Appeal Decision

Appeal Ref: APP/R5510/W/18/3218579

31 Morello Avenue, Uxbridge UB8 3ES

- The appeal is made under section 78 of the Town and Country Planning Act 1990 against a refusal to grant planning permission.
 - The appeal is made by Ms Parminder Kaul against the decision of the Council of the London Borough of Hillingdon.
 - The application Ref 72026/APP/2018/2672, dated 19 July 2018, was refused by notice dated 5 November 2018.
 - The development proposed is conversion of house into 5 bedroom House in Multiple Occupation (Sui Generis) (maximum occupation by 6 persons).
-

Drawing Title
Existing Floor Plans (no changes proposed)

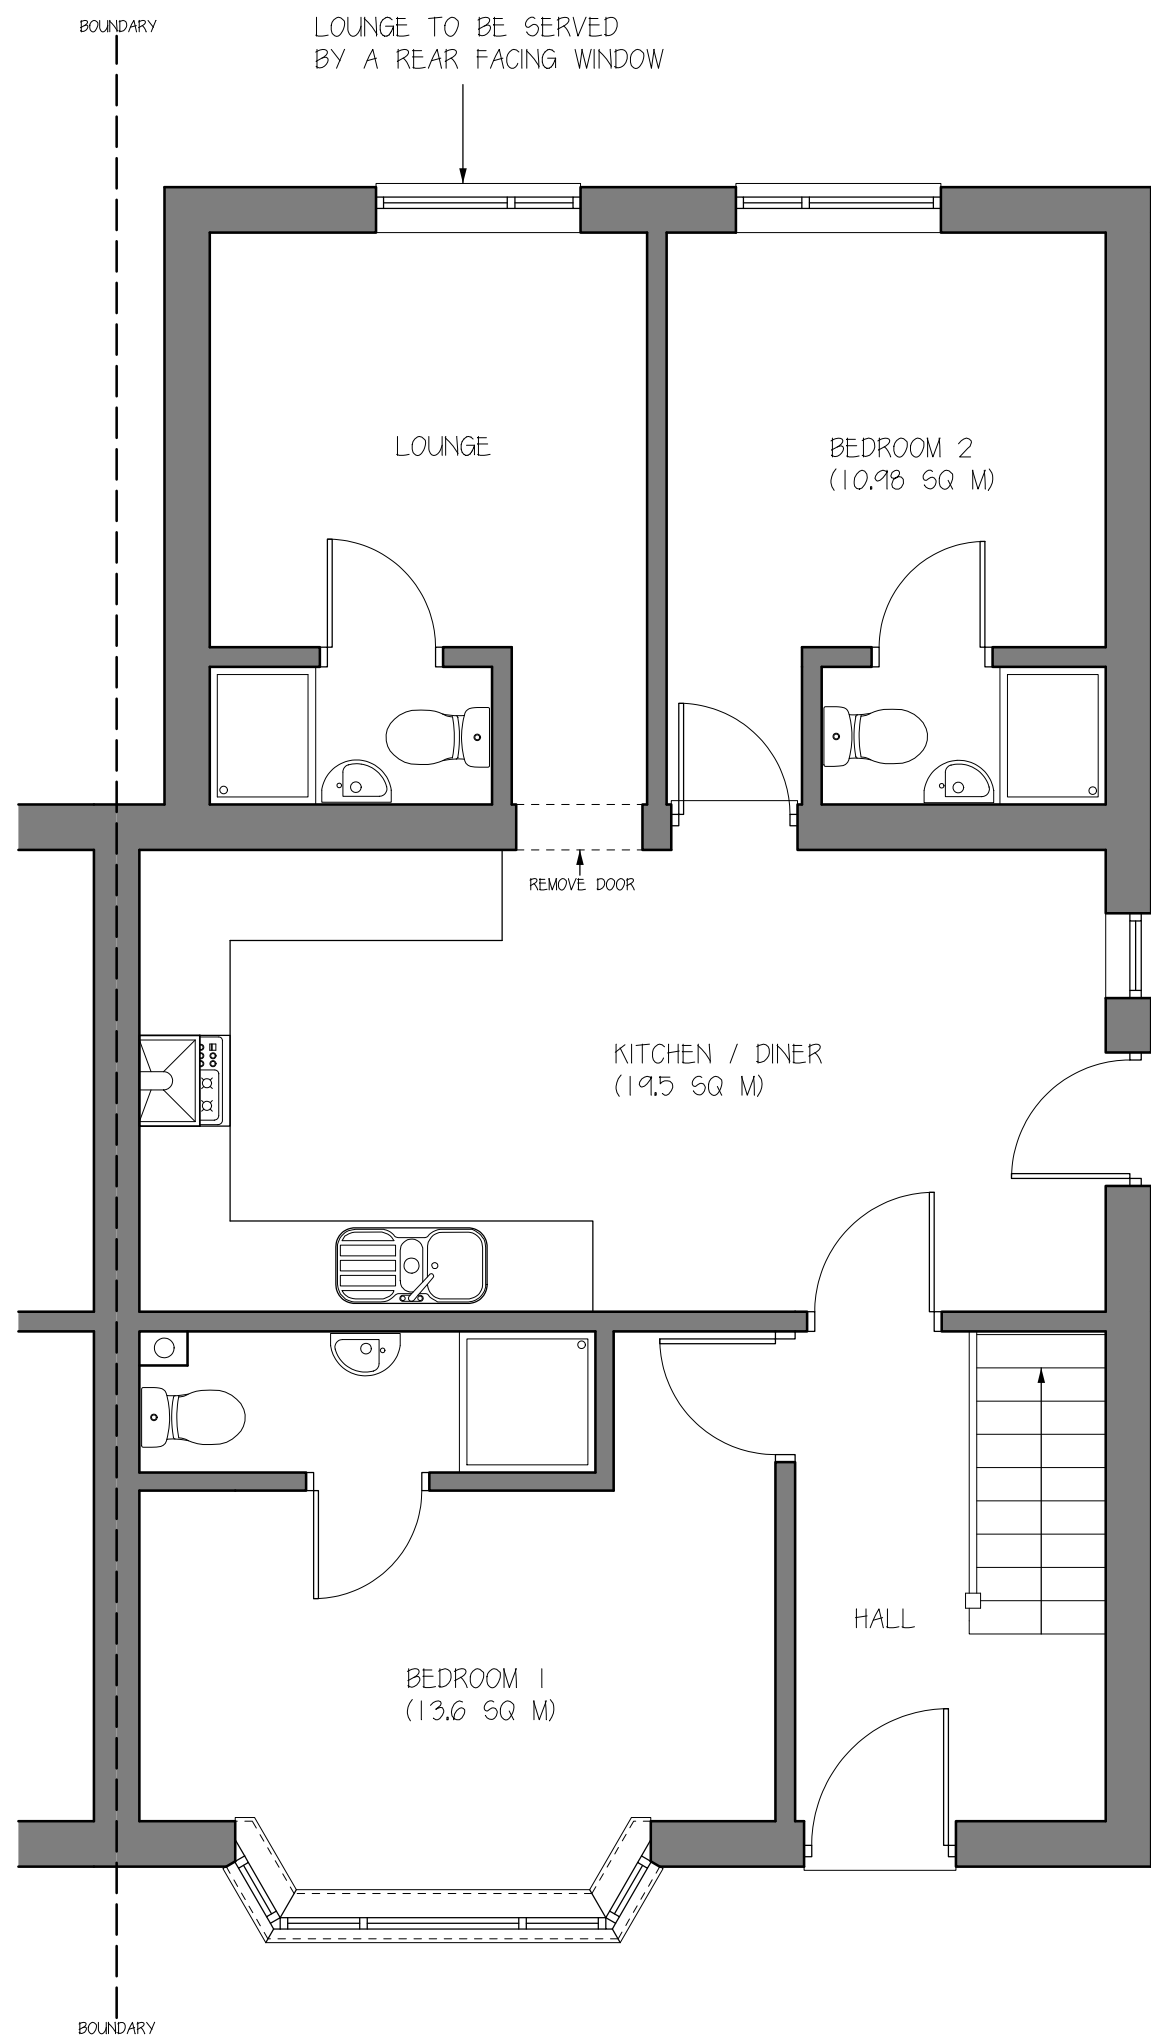
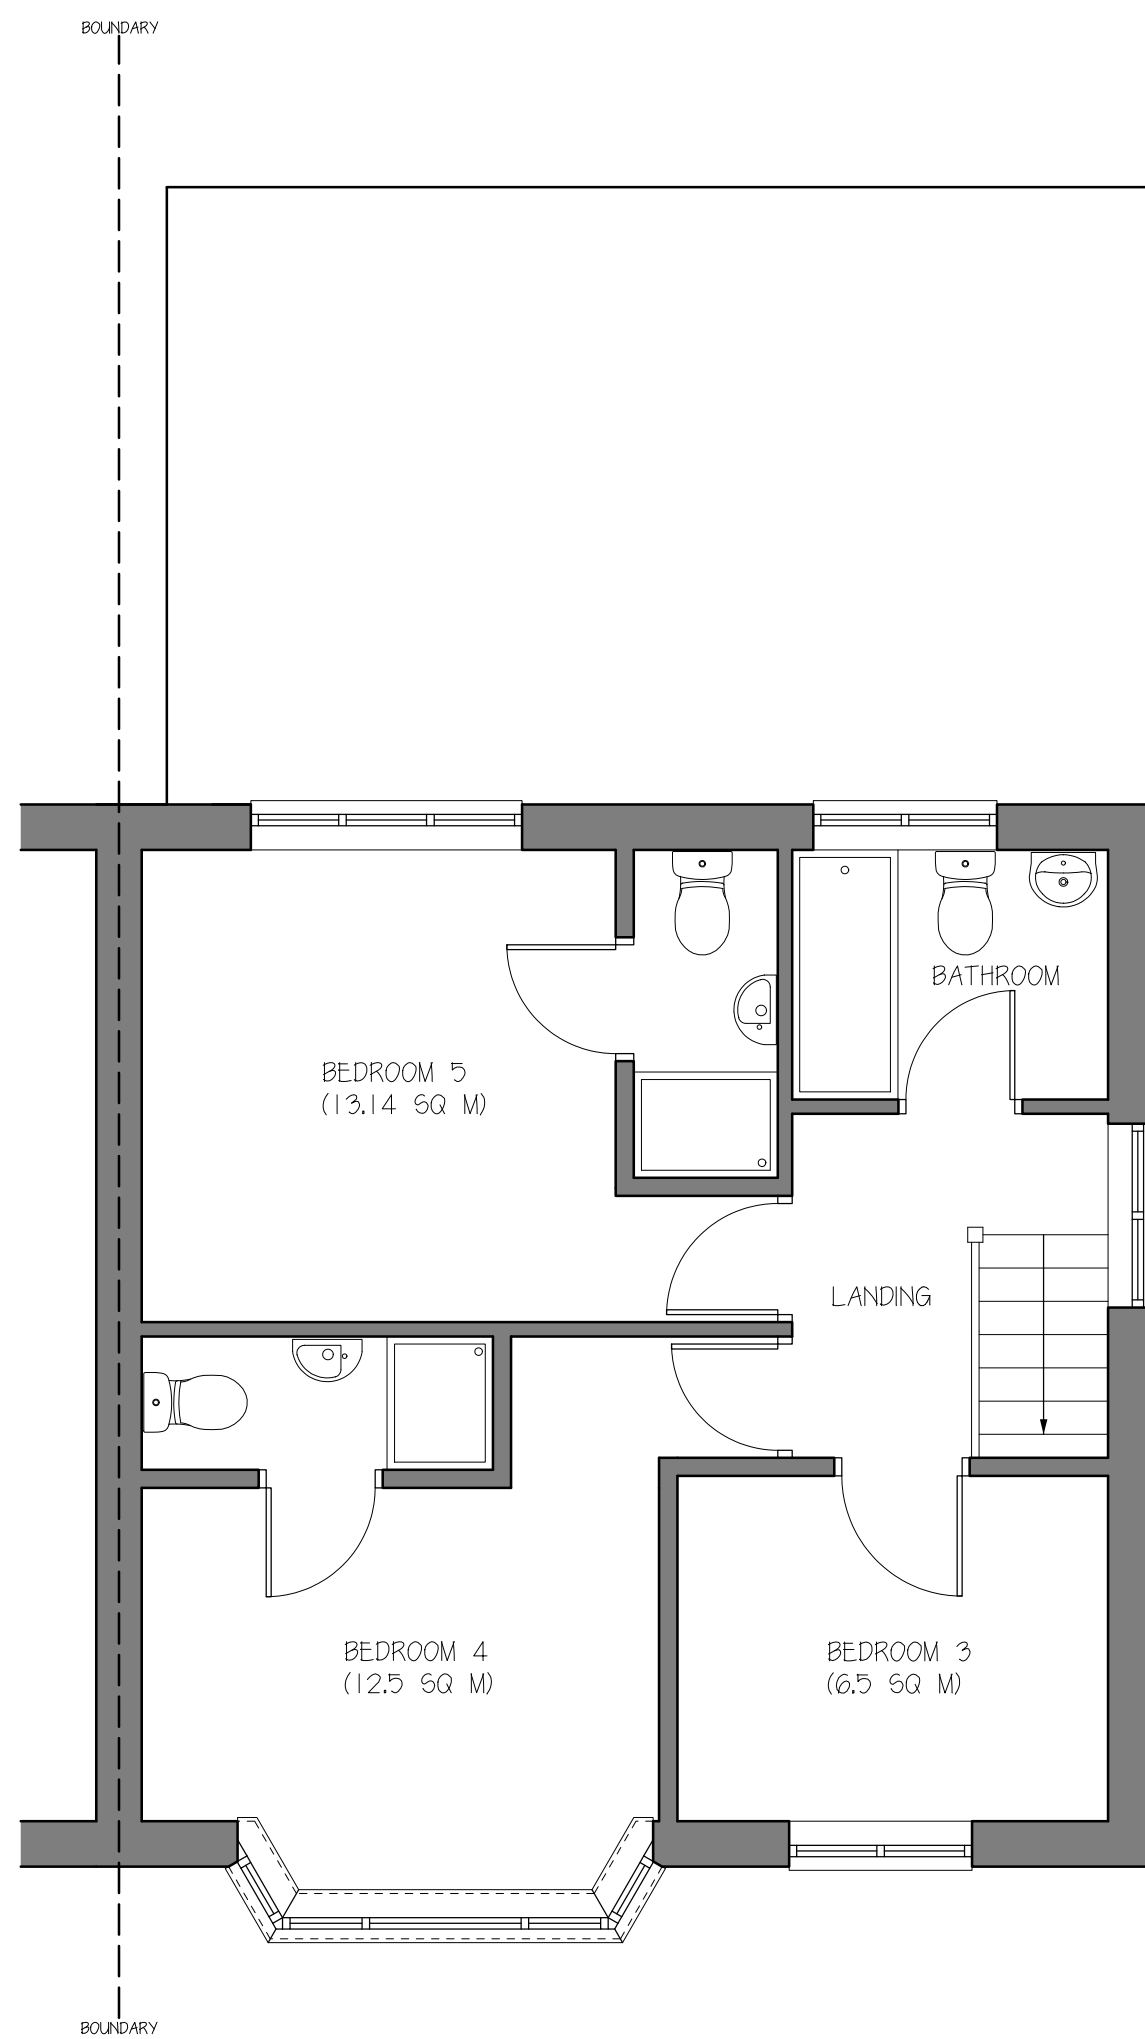
6. The previous proposal for a 6-bedroom HMO included a third bedroom on the ground floor, and what is now proposed as the kitchen/diner was the only communal living space. In considering that scheme the Inspector found that the outlook from, and light level in, the communal kitchen/lounge would not provide satisfactory living conditions for future occupiers. The communal living facilities now proposed include a separate lounge, which would be linked to the kitchen/diner by the removal of the door between them. I observed that, in all other respects, the physical characteristics affecting light levels in, and outlook from, the kitchen/diner remain the same as described by the Inspector.

7. The proposed lounge is described on the drawings as being 10 sq m in area, but the useable space would be reduced by the retention of the en-suite shower/wc and the necessary circulation space. Consequently, it would not be capable of accommodating many of the potential nine occupants at any one time. As a result, there would still be a significant reliance on the kitchen/diner to provide day to day living space. I observed that the removal of the door would make little difference to light levels in the kitchen area. I also saw that the window in the lounge would not be visible from most of the kitchen/diner, and would not therefore improve outlook from this room to any significant extent. I therefore conclude that the proposal would not provide the residents with satisfactory living conditions, due to the unacceptably low level of natural light in, and outlook from, the kitchen/diner where residents would be likely to spend much of their time.

8. Bedroom 3 measures 6.5 sq m, which is the minimum room size for single person occupancy set out in the Council's SPG. However, the SPG pre-dates the government's Technical Housing Standards – Nationally Described Space Standard (March 2015) (the NDSS) and the London Plan (2016). Policy 3.5 of the London Plan adopts the NDSS, which sets a minimum floorspace for a single bedroom at 7.5 sq m. Bedroom 3 falls below this standard. This was not considered by the previous Inspector because it was not an issue that had been raised by the Council at that time. Nonetheless it is a matter that I must consider in this appeal.

9. The occupant of Bedroom 3 would have very cramped conditions for sleeping and storing all personal belongings, bearing in mind that this would be an HMO and therefore all other parts of the property would be shared with unrelated people. The limited space available in Bedroom 3 means that the occupant would be particularly reliant on the communal living space. I have already

concluded that the light in, and outlook from, the communal living space is unsatisfactory. The limited floorspace in Bedroom 3 therefore contributes to my overall finding that the proposed accommodation would not provide suitable living conditions for future occupants.
